2024/0694

Police Station House, Wood Walk, Platts Common, Barnsley, S74 9SH

**Remove existing conservatory and erection of first floor side extension with rear facing balcony, new car port and single storey rear extension, entrance lobby and relocation of fence and gates.**

Drawing Title
PROPOSED LAYOUTS AND
CARPORT ELEVATIONS

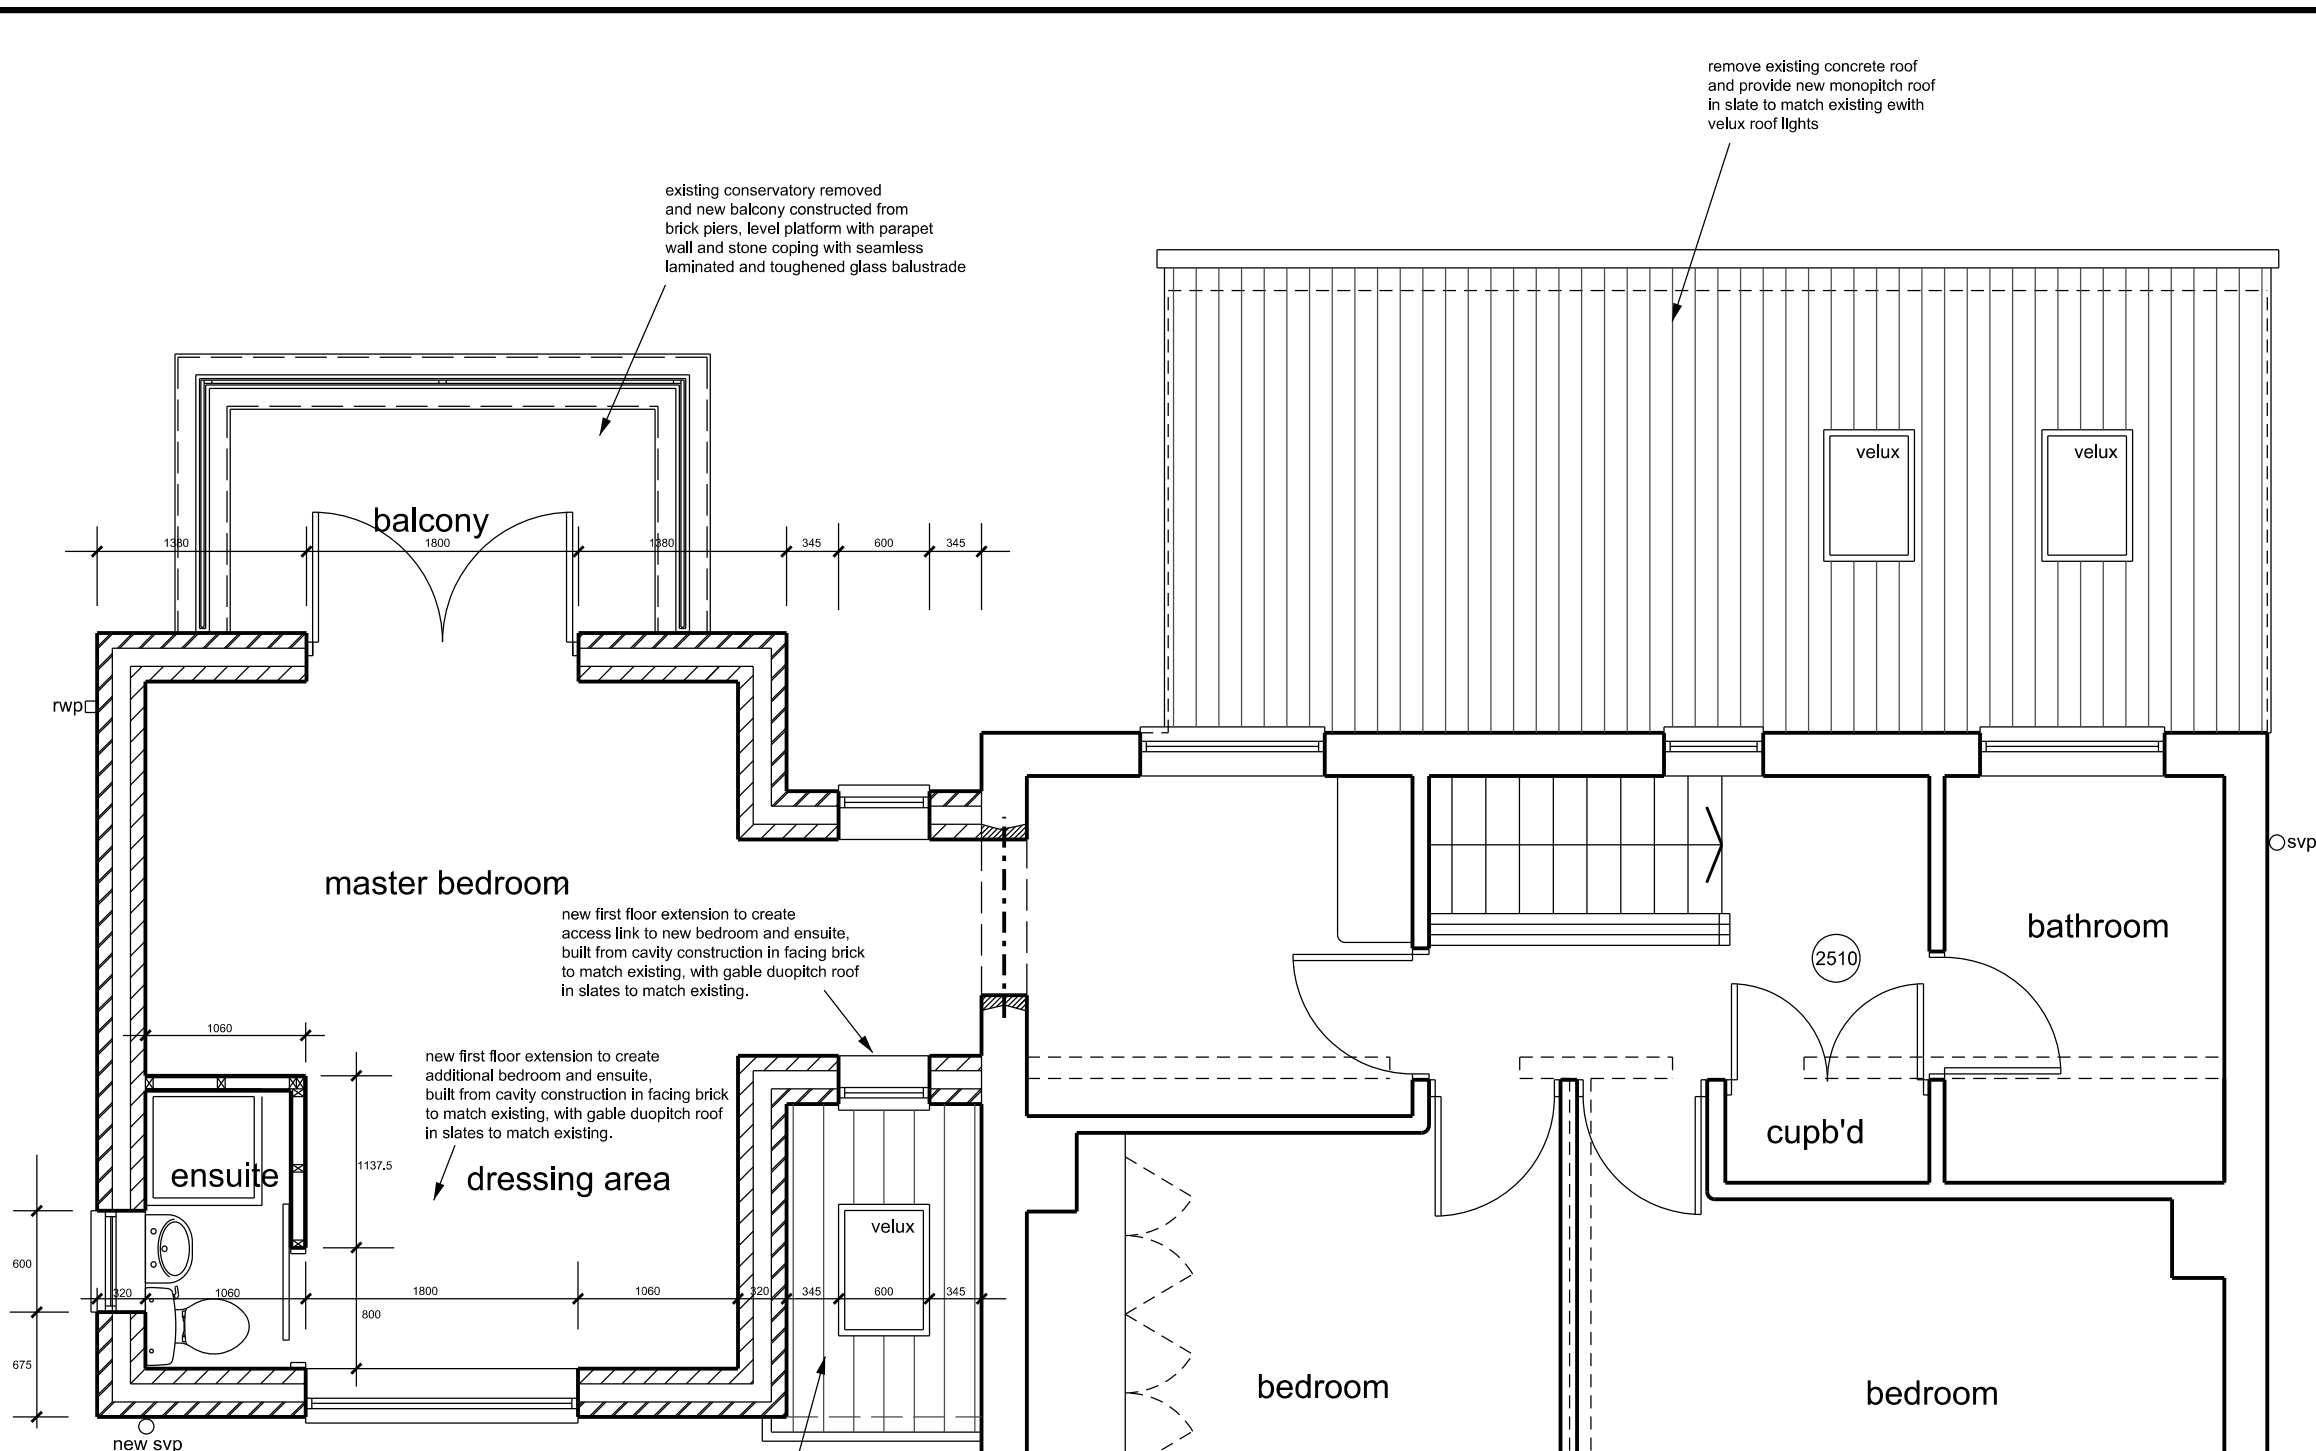
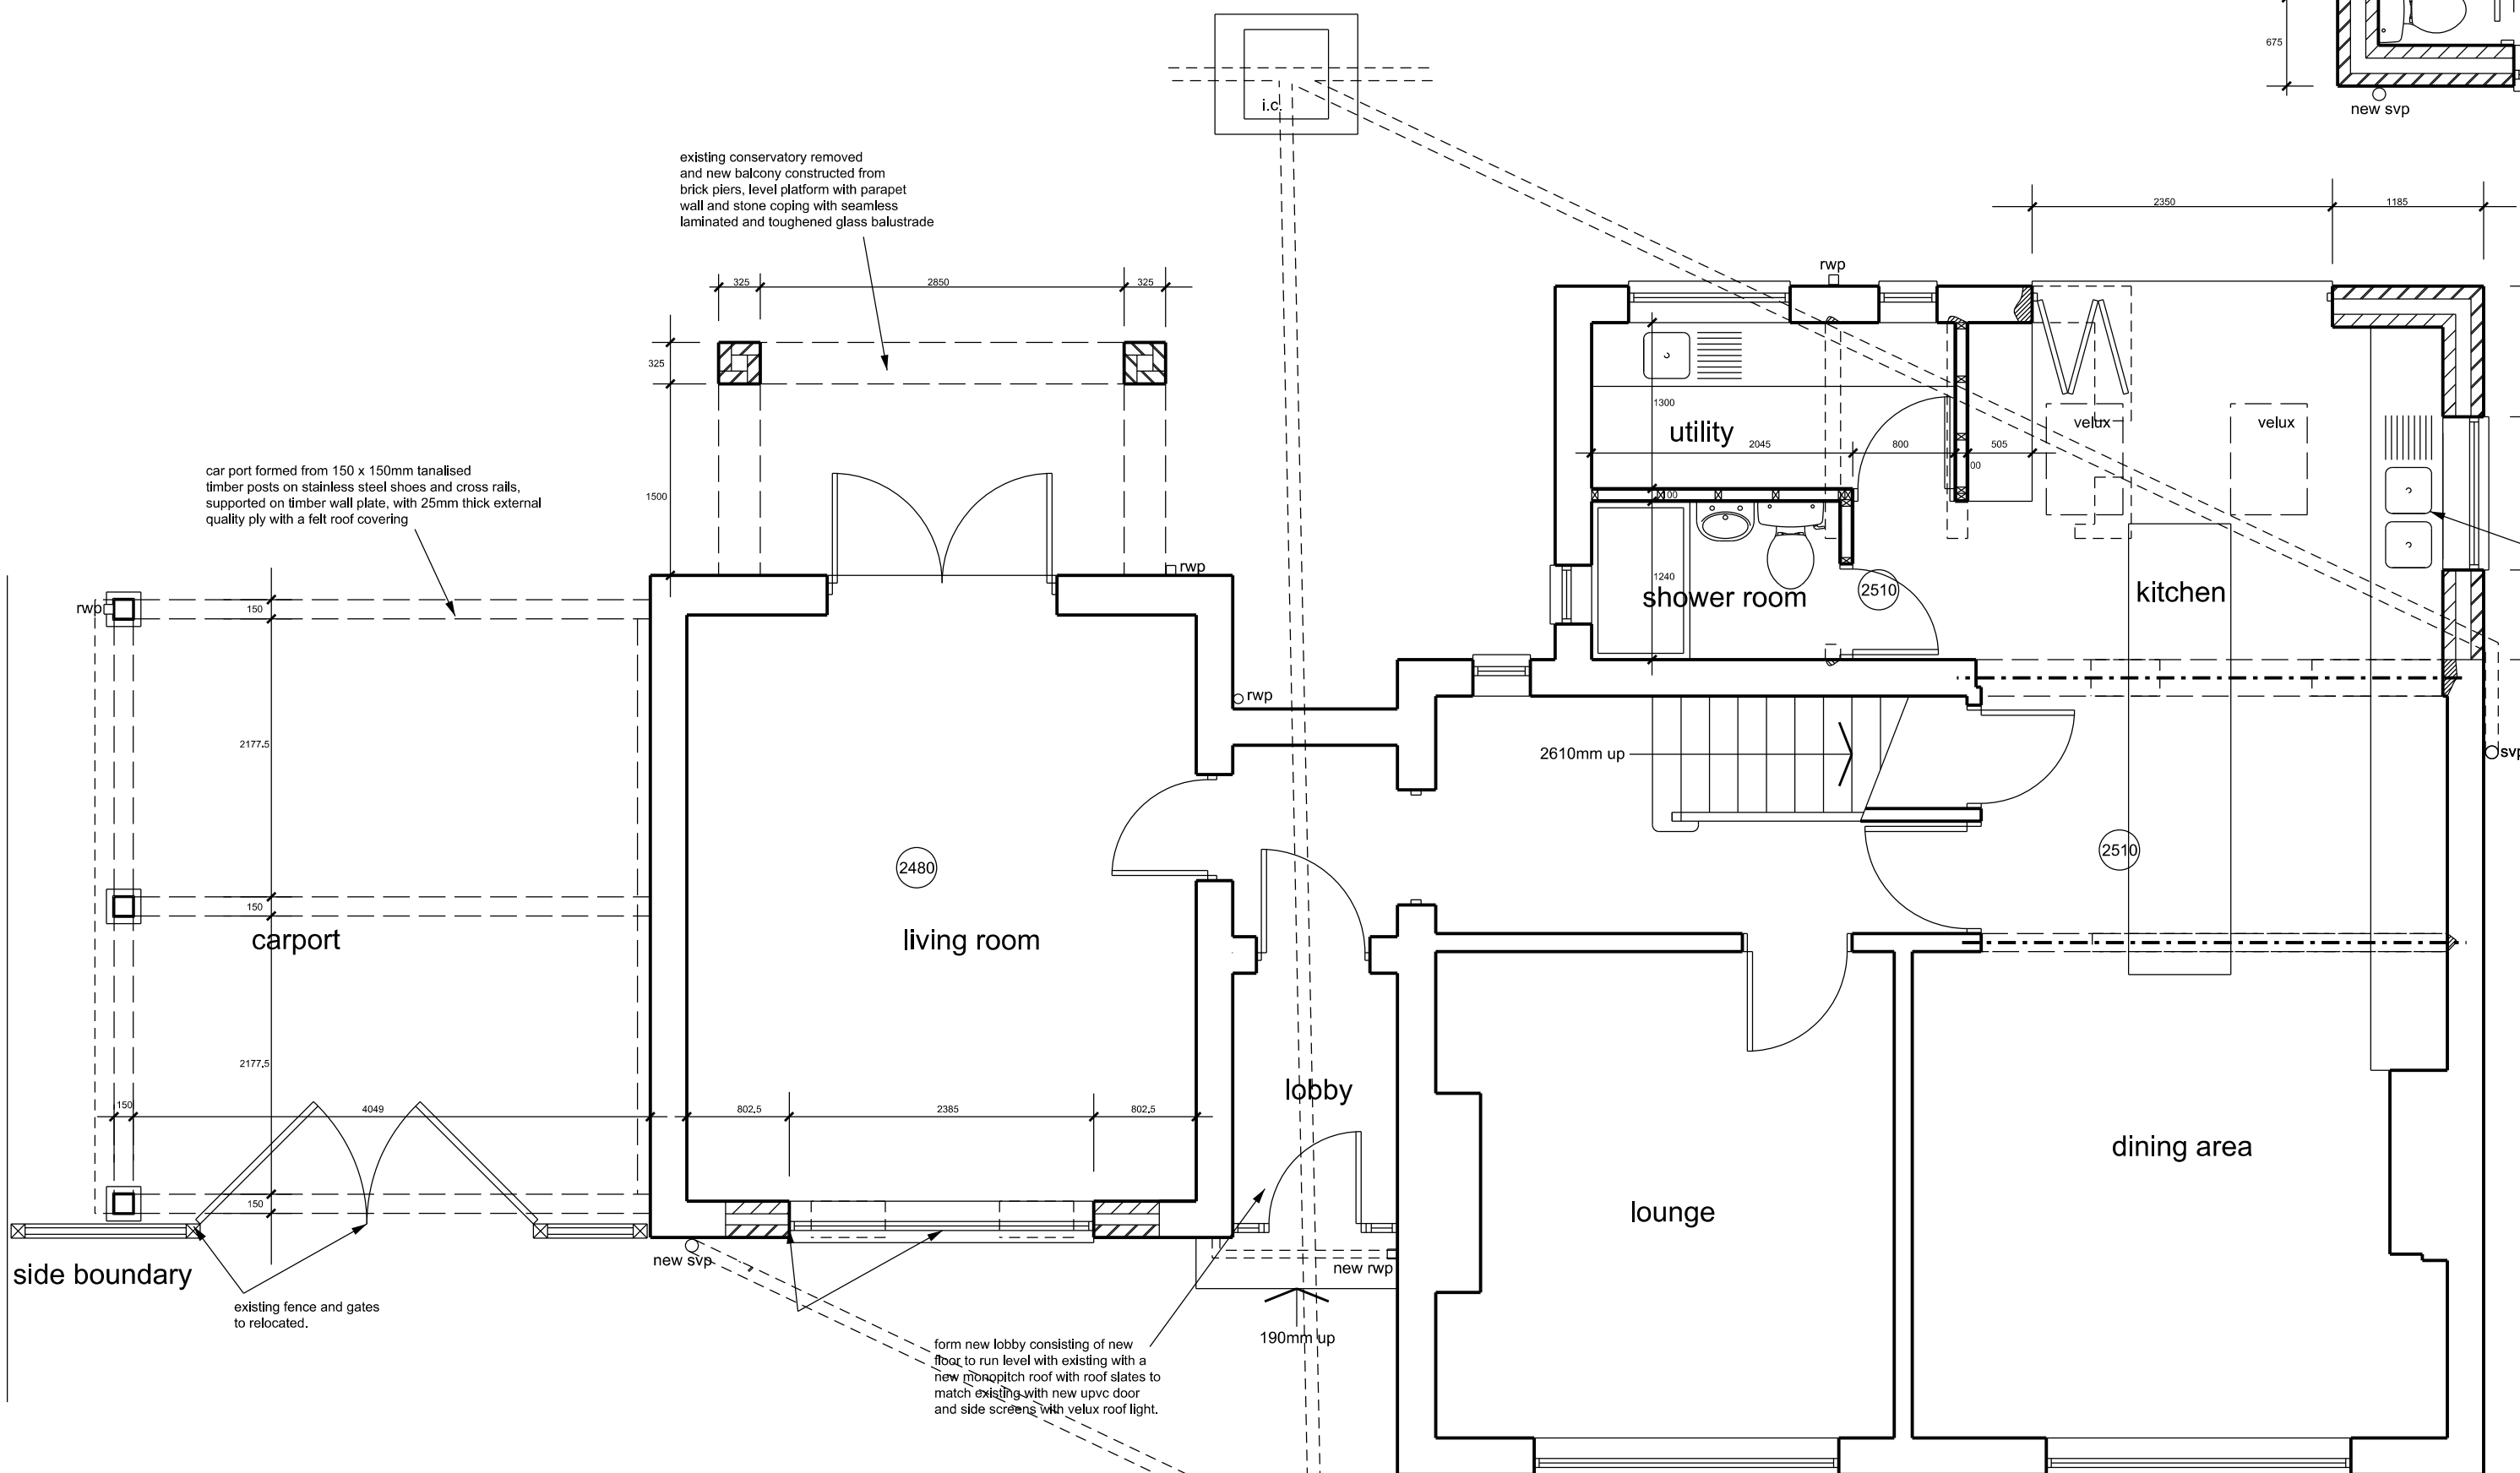
The proposed car port would not adopt an excessive sideways projection more than two thirds the width of the original dwelling and would have a neutral appearance in the street scene due to its timber frame and being open on all sides. In addition, the car port would be set significantly back from the highway and would not be an overly prominent or dominant feature in the street scene.
